PLANNING CONSULTATION RESPONSE

Application No	2025 0908
Proposal	Re-engineering and Restoration of Yew Tree Quarry through the importation of non hazardous Excavated Soil Materials
Address	Stairfoot Brickworks, Wombwell Lane, Stairfoot, Barnsley, S70 3NS
Date of Consultation Reply	02/12/2025
Consultee	PROW – S Ford

VIEWPORT 3 - SWEEP PATH ANALYSIS (SCALE 1:1000@A1)

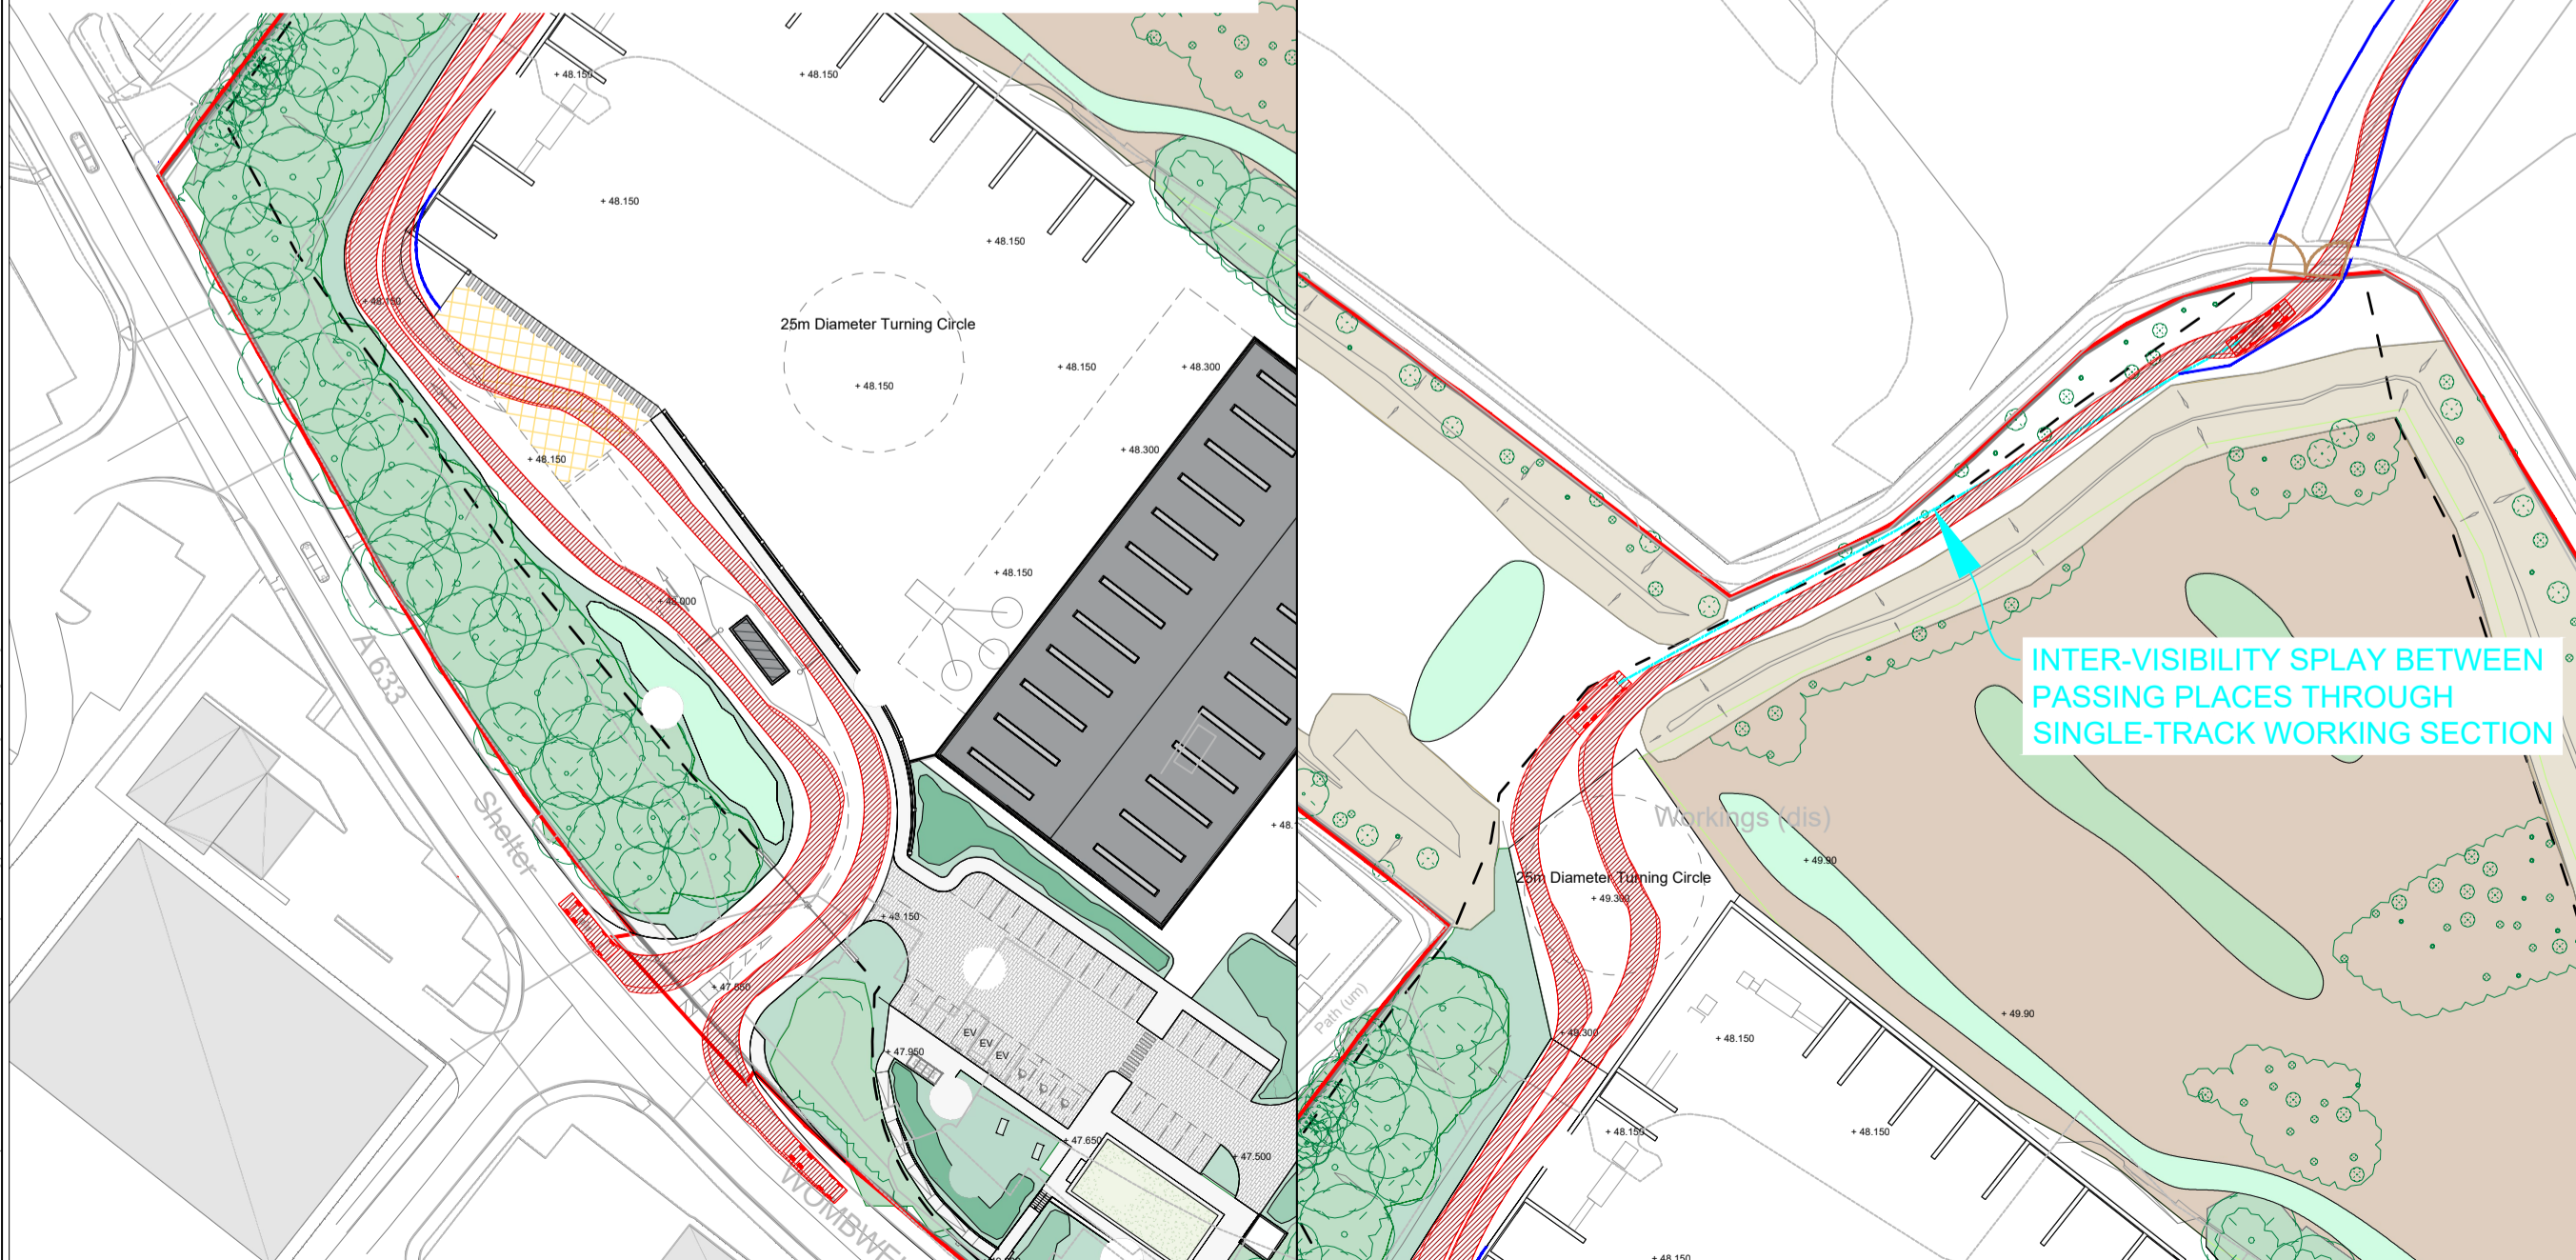
[Figure 3.4 proposed site access arrangements](#) refers to a more detailed plan of the TPT/Access Road crossing as being 3263-01-D02 but unable to find that on the planning file. There are 3 copies of the same footpath diversion plan under different titles!

PRIORITY MUST BE GIVEN TO TPT BRIDLEWAY USERS IN TERMS OF GATES.

Vehicles will need to wait for a banksperson to open the gates (which would then be across the TPT) to allow vehicles to go through along the access road and reopening the crossing to TPT users as soon as it has passed.

The developer must also ensure that at the end of the working day/ when there is no banksman, the gates are prioritising TPT users or it risks accidents and incidents for which it will be liable

Having the gates the other way round risks trapping lots of TPT users on both sides of the crossing point with horses that then could be spooked by vehicles or just the noise and injure themselves of other users.

As well as priority for gates at the crossing, there needs to be plenty of warning signs in both directions that users might come across closed gates to allow vehicles through and what to do.

No works shall start until the TPT and vehicle crossing point issues have been agreed. Priority must be given to the TPT crossing over the vehicle access road, during any vehicle movement periods a banksperson must be in place at the crossing and overnight/weekends the TPT must be open and available to use
